# CITY OF ALBUQUERQUE

**RE: Wintergreen Apartments  
10800 Golf Course Rd NW  
Grading & Drainage Plan and Drainage Report  
Engineer's Stamp Date: 08/26/21  
Hydrology File: A12D008D**

**RE: WINTERGREEN APARTMENTS  
10800 GOLF COURSE RD NW  
GRADING & DRAINAGE PLAN AND DRAINAGE REPORT  
HYDROLOGY FILE: A12D008D**

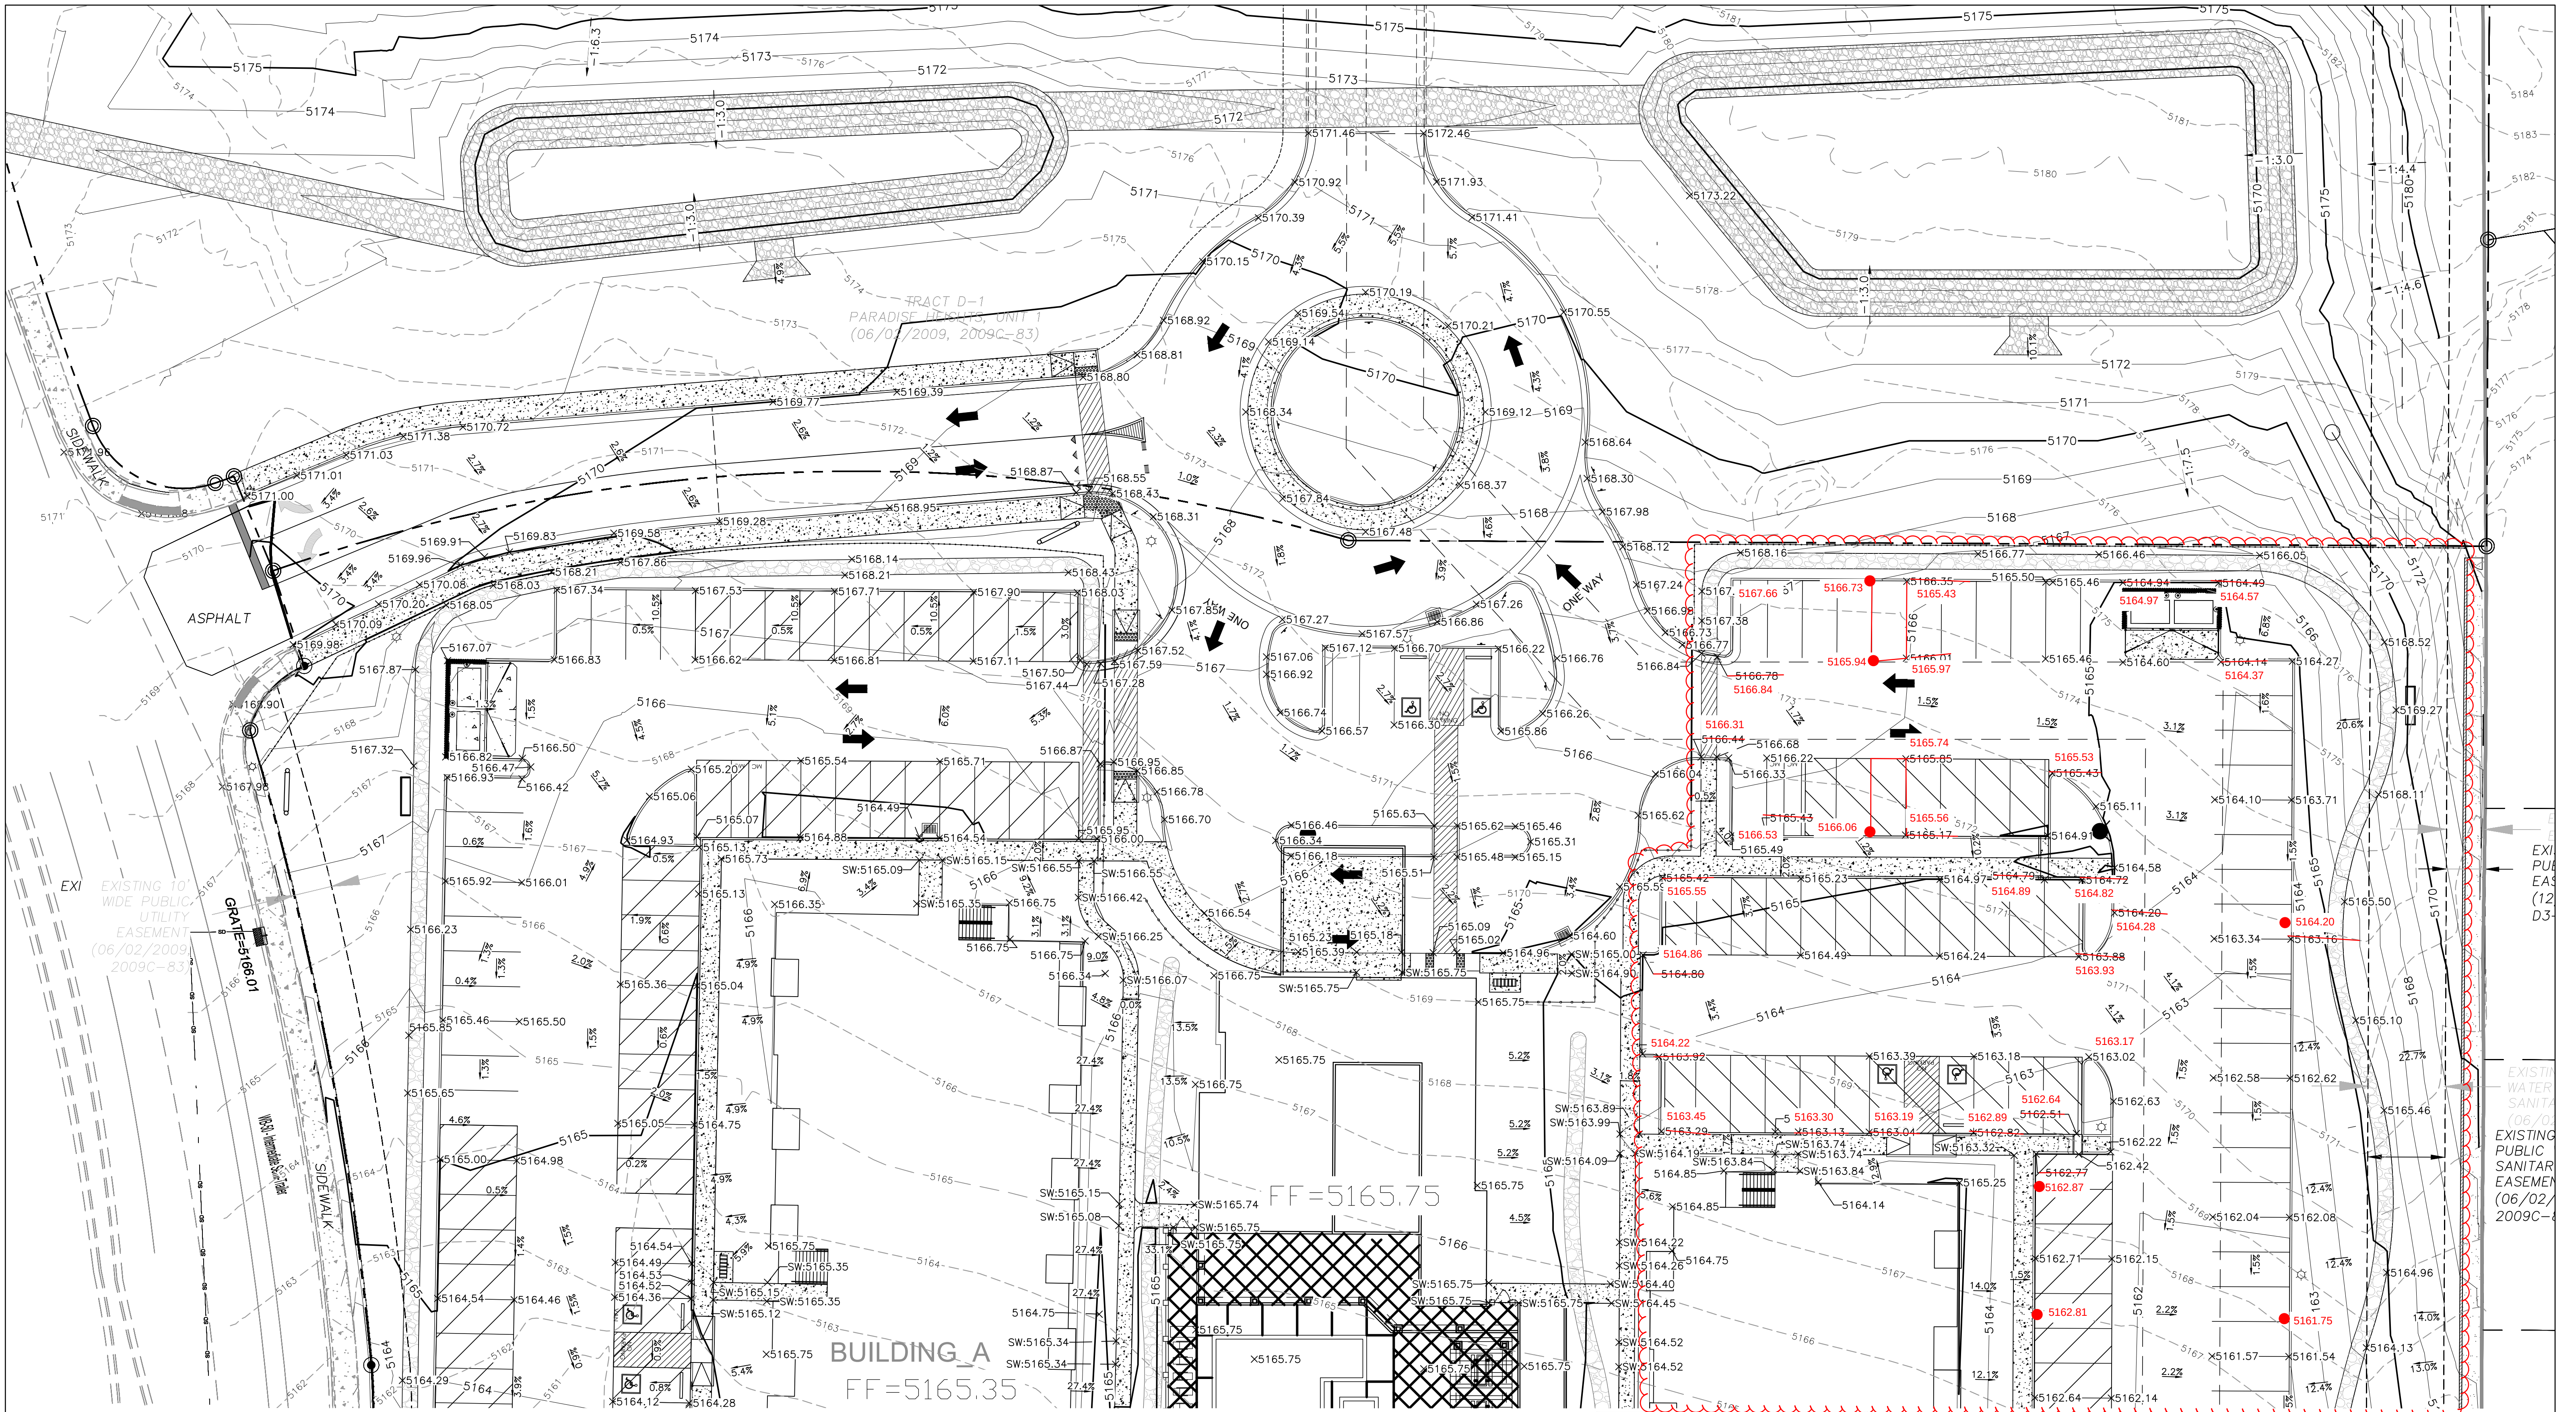
1. The water quality pond has pretty steep slopes. How is it going to be access and maintained? You have enough room behind the parking to add an access ramp.

**Response: See sheet C3.2, access ramp with gate added to water quality pond.**

6. Please reference City of Albuquerque standard detail No. 2236 – Sidewalk Culvert with Steel Plate Top at the sidewalk culvert.

**Response: See updated sheet C3.2 and detail No. 2236 was added to sheet C6.4.**
